# CITY OF ALBUQUERQUE

**Re: La Vista at Desert Ridge Subdivision Grading and Drainage Plan  
Engineer's Stamp dated 12-30-11 (C19/D042)**

## CITY OF ALBUQUERQUE PUBLIC WORKS DEPARTMENT TRANSPORTATION DEVELOPMENT LA VISTA DESERT RIDGE SUBDIVISION GRADING AND DRAINAGE PLAN

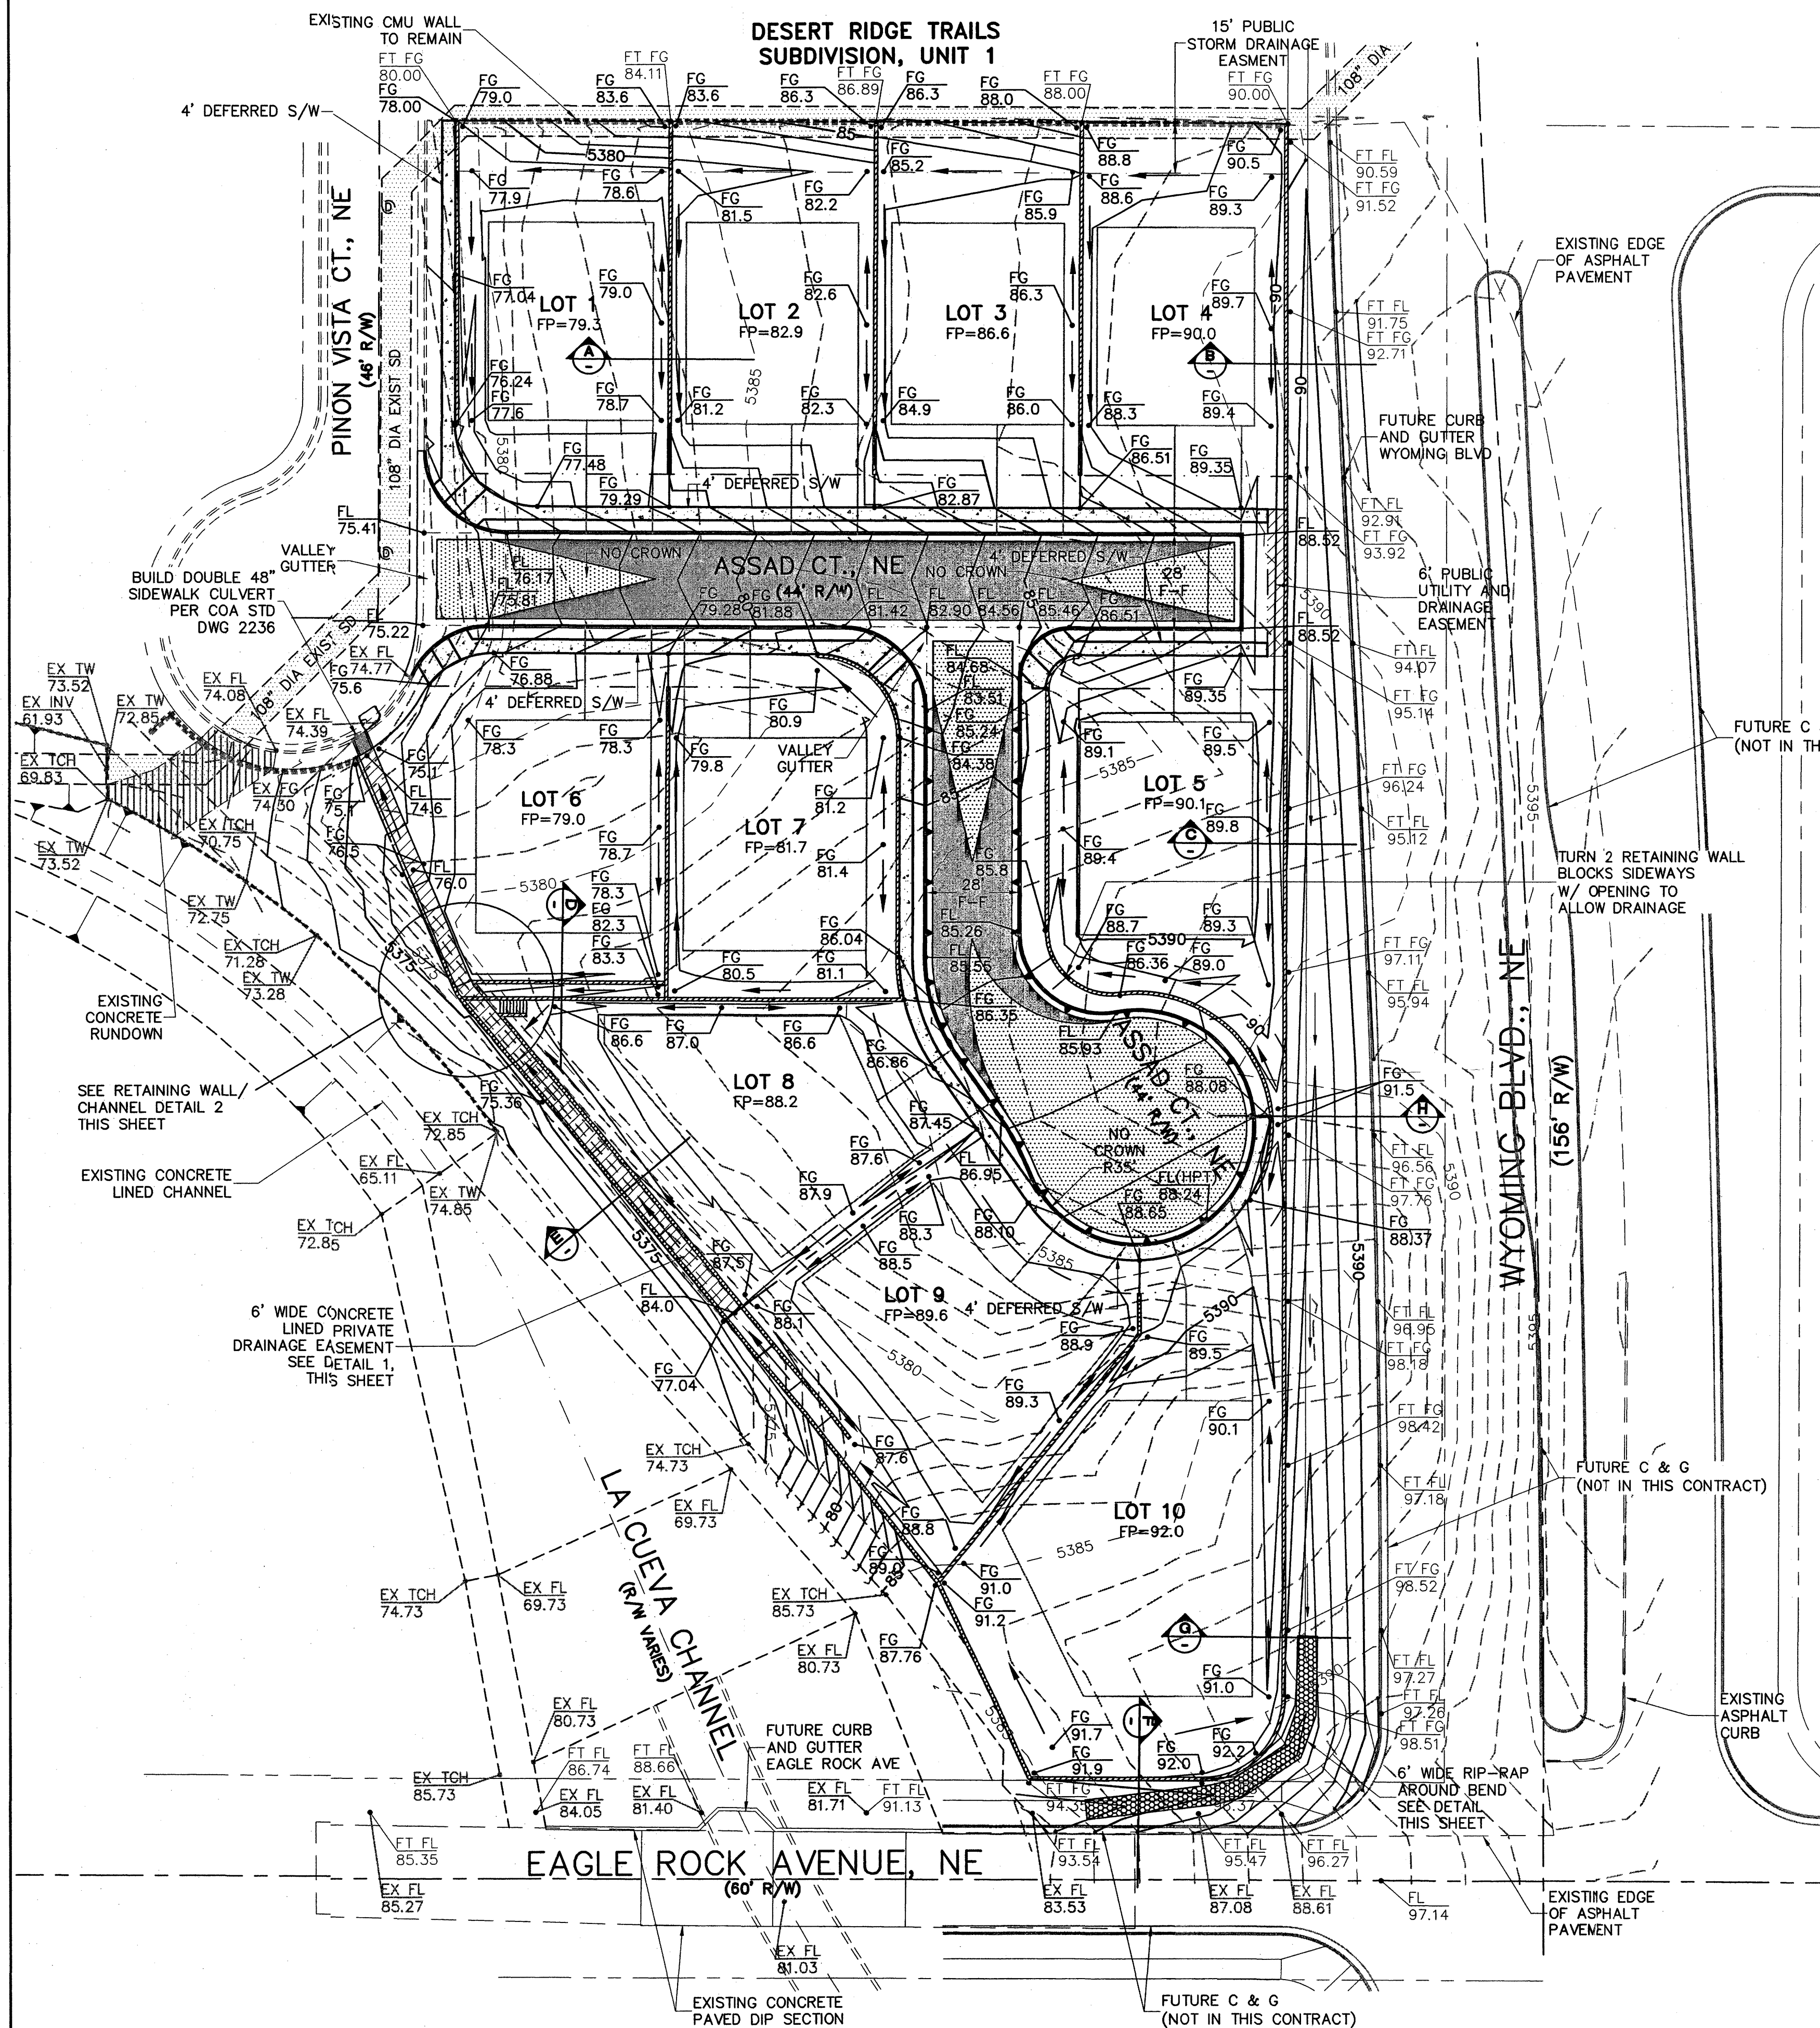
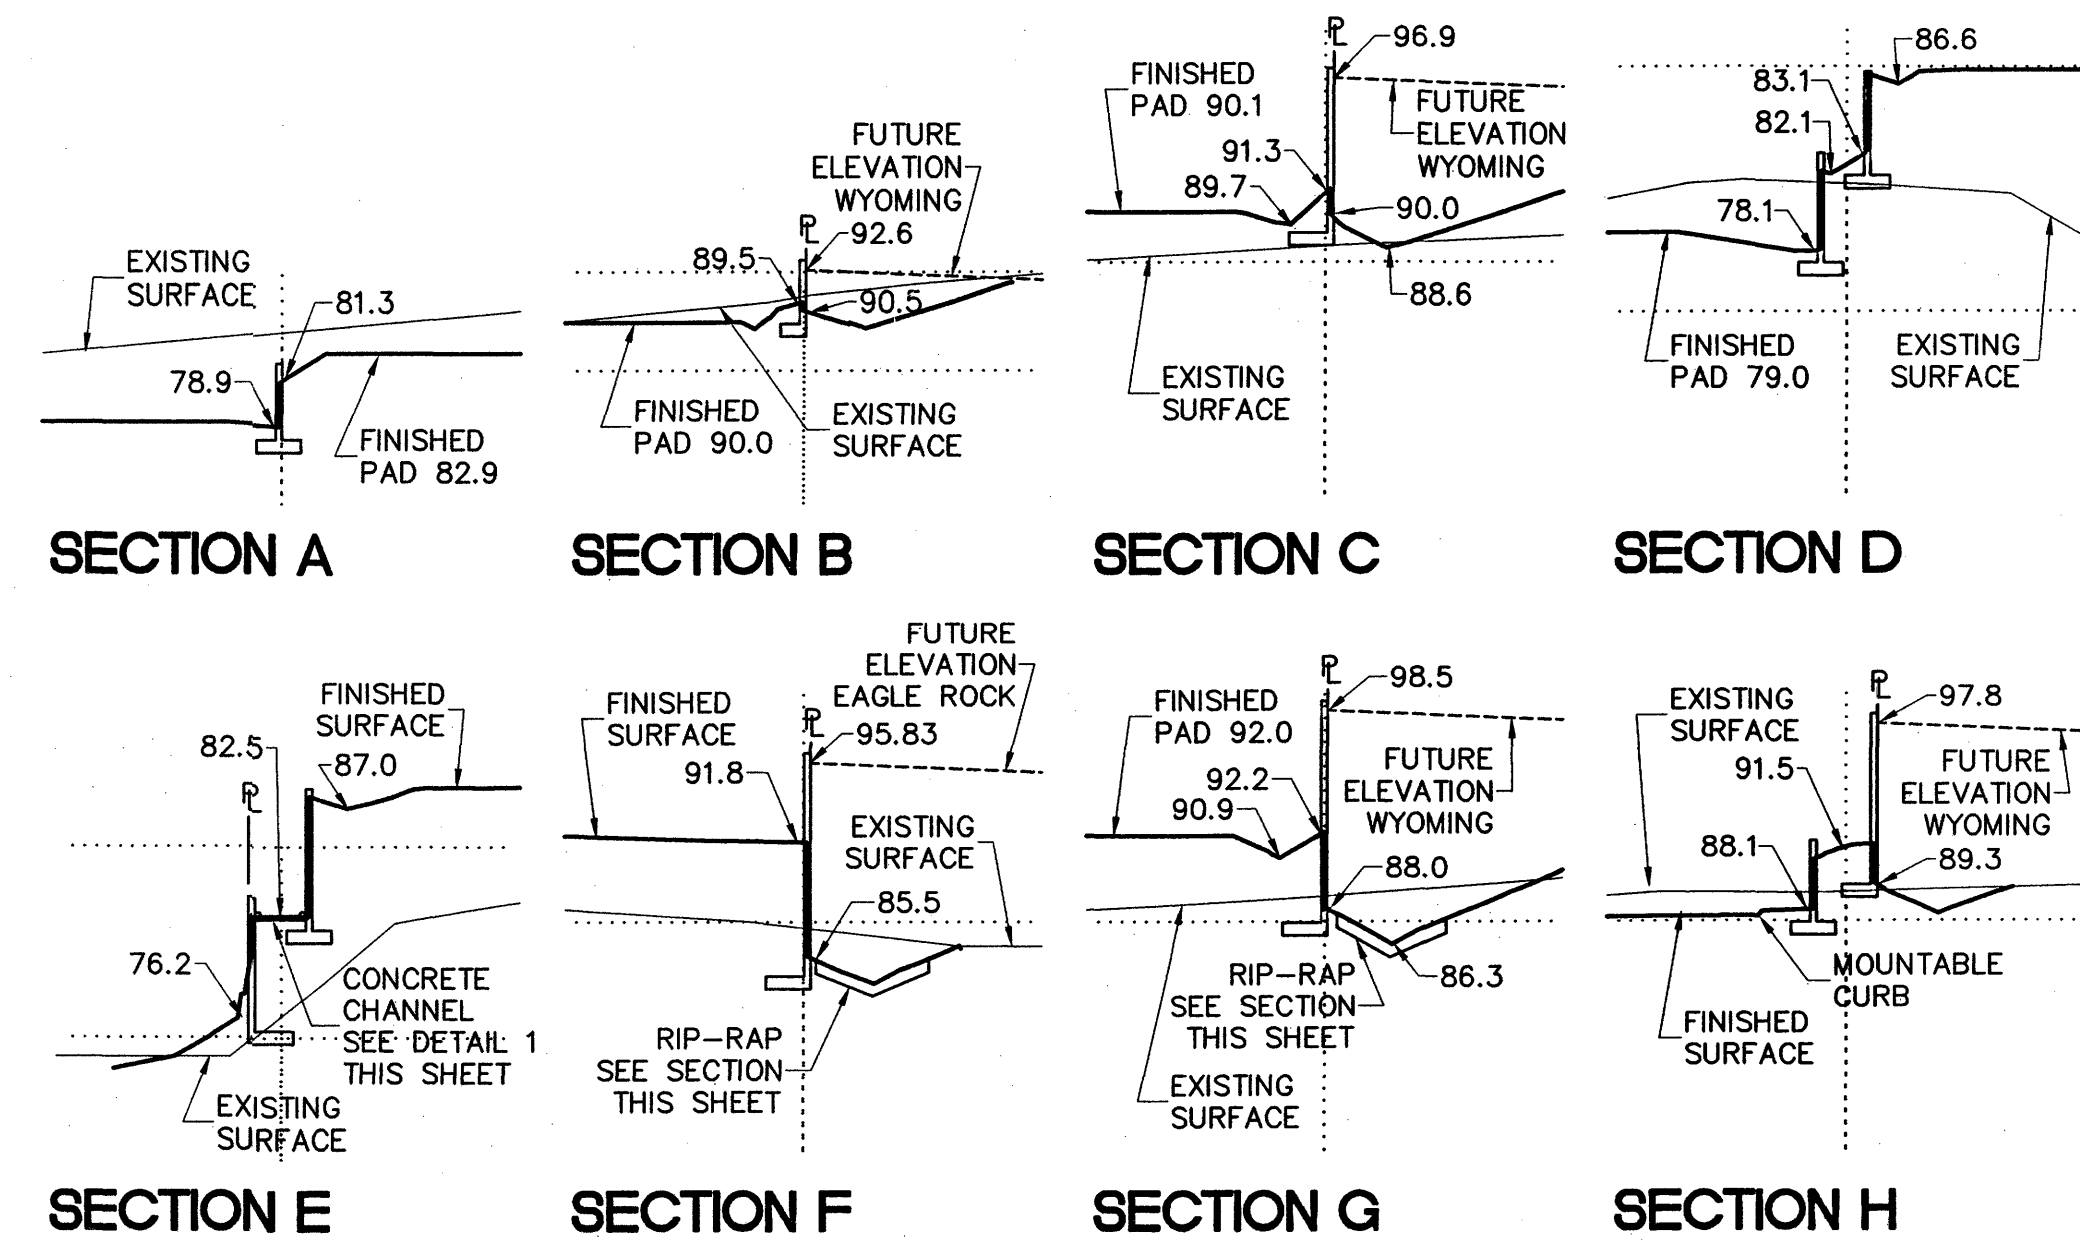
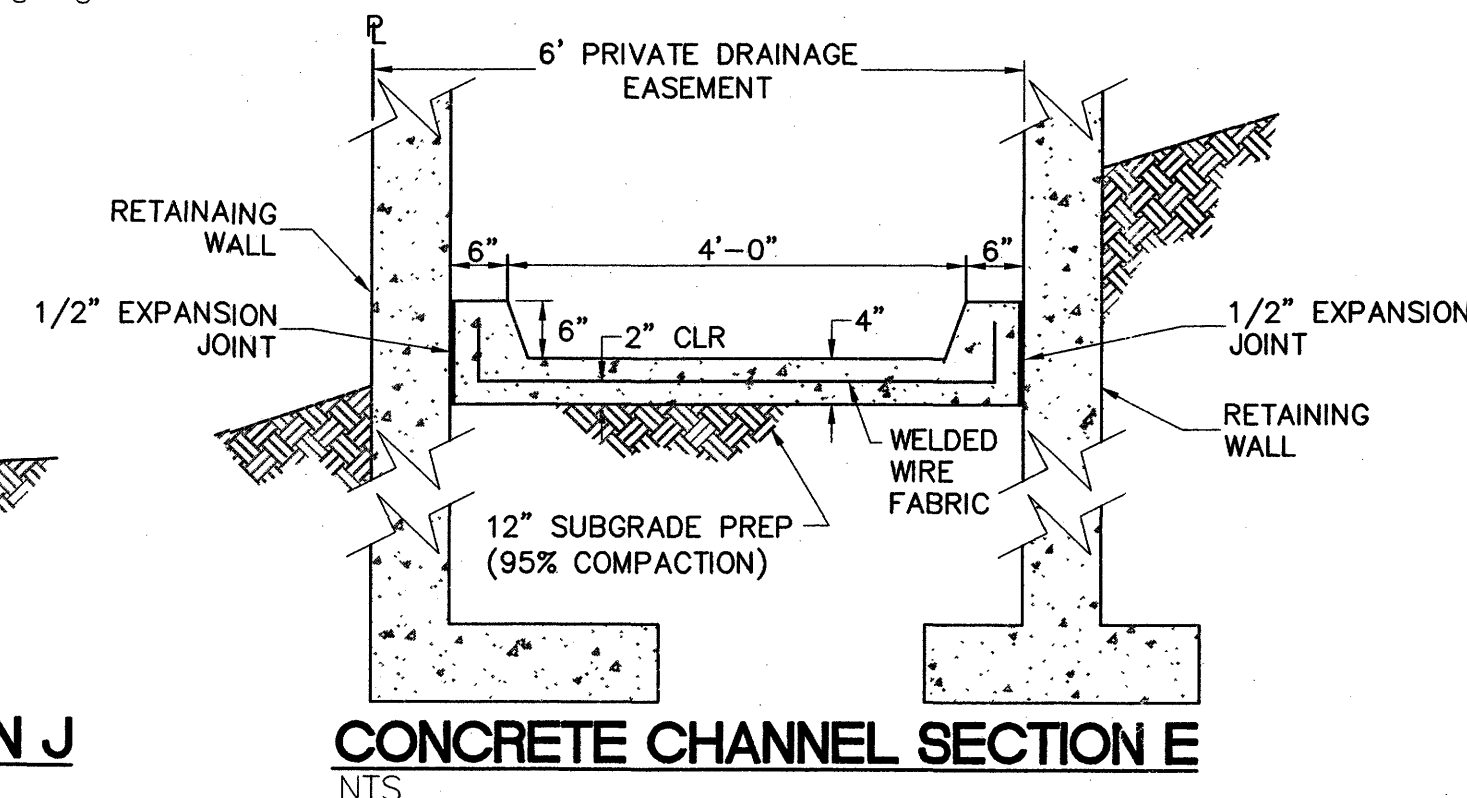
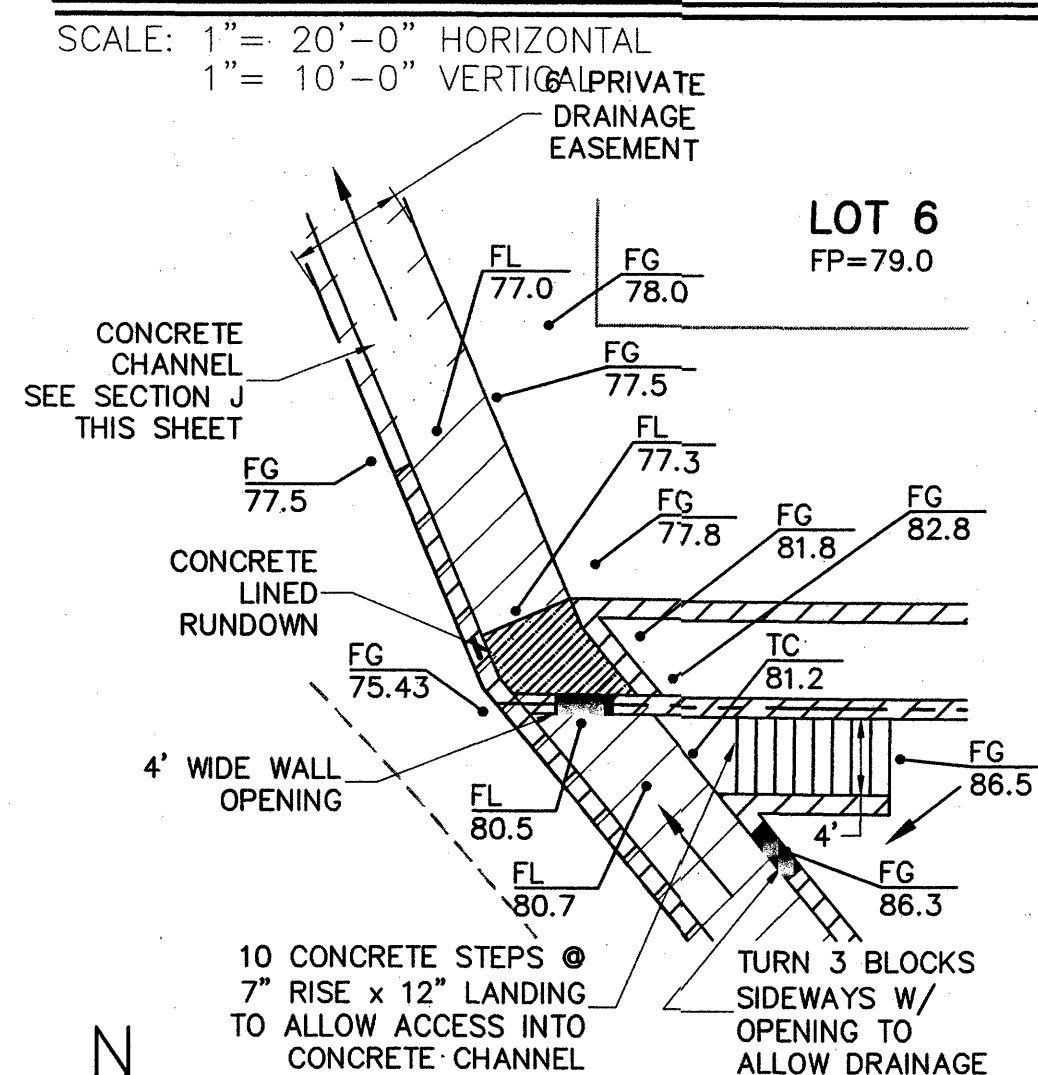
Based upon the information provided in your submittal received 1-3-12, the above referenced plan cannot be approved for Work Order or Grading Permit. An earlier Grading Plan was approved for Preliminary Plat action by the DRB.

- As the Work Order process developed it was not clear that the section of Wyoming Blvd. that fronts this property would be constructed. The section of Wyoming Blvd. that fronts this property is on the Infrastructure List so it should be built with the Work Order for the Subdivision.
- Therefore, show the proposed section of Wyoming Blvd on the Grading Plan as well as grading (e.g. fill with tie slope) on Lot 17 to support the construction of Wyoming Blvd.
